TfNSW Reference: SYD21/00245/04

Client Reference: SSD-15001460

EXHIBITION OF EIS - HAWKESBURY CENTRE OF EXCELLENCE - LONDONDERRY ROAD, RICHMOND

Figure 24 | Construction vehicle access routes (Source: Applicant's RtS 2021)

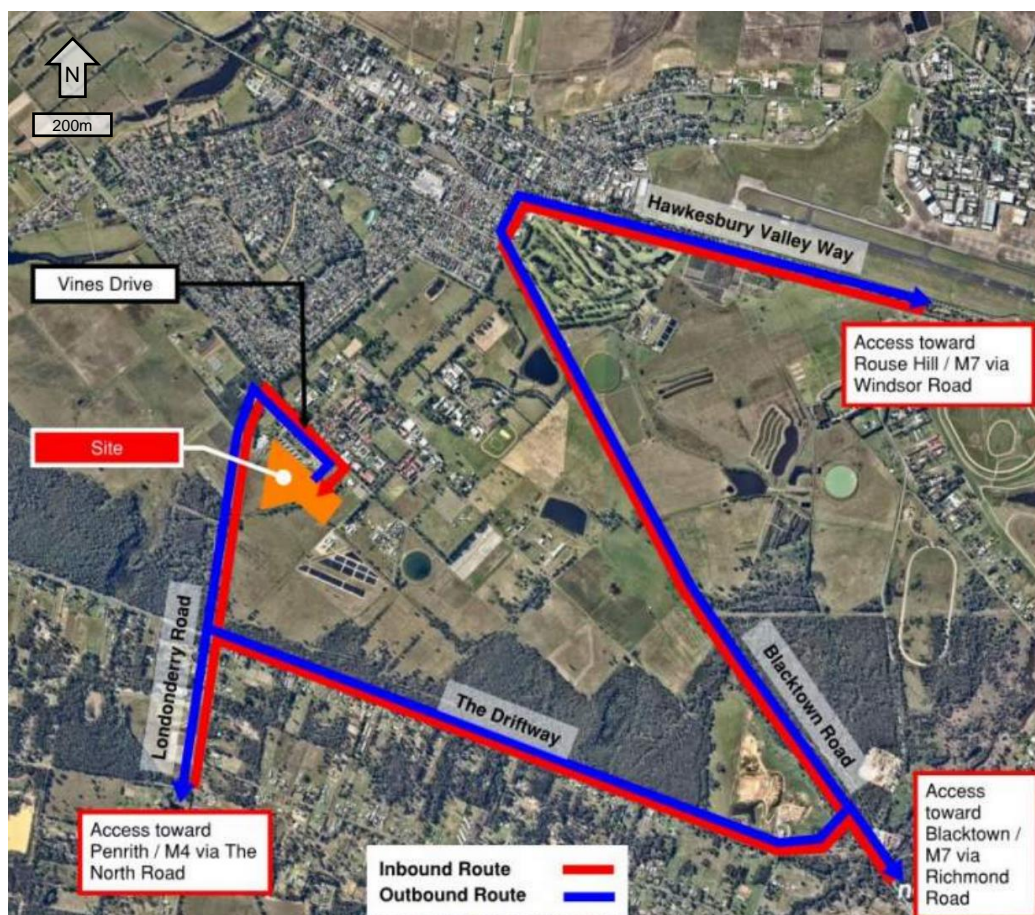
There is discrepancy regarding the construction vehicle haulage route information provide within the TAIA and the Construction Management Plan.

It is requested that the applicant updated the Environment Impact Assessment with consistent information.

If access from Londonderry Road is proposed for construction vehicles, concurrence is required from TfNSW under Section 138 of *Roads Act 1993*, as Londonderry Road is a classified Road. Concept design plans of the proposed temporary Londonderry Road access are to be submitted to TfNSW for approval. The redundant access, when construction is completed, shall be removed and replaced to match existing. A sight

distance assessment should be undertaken and submitted to TfNSW for review.
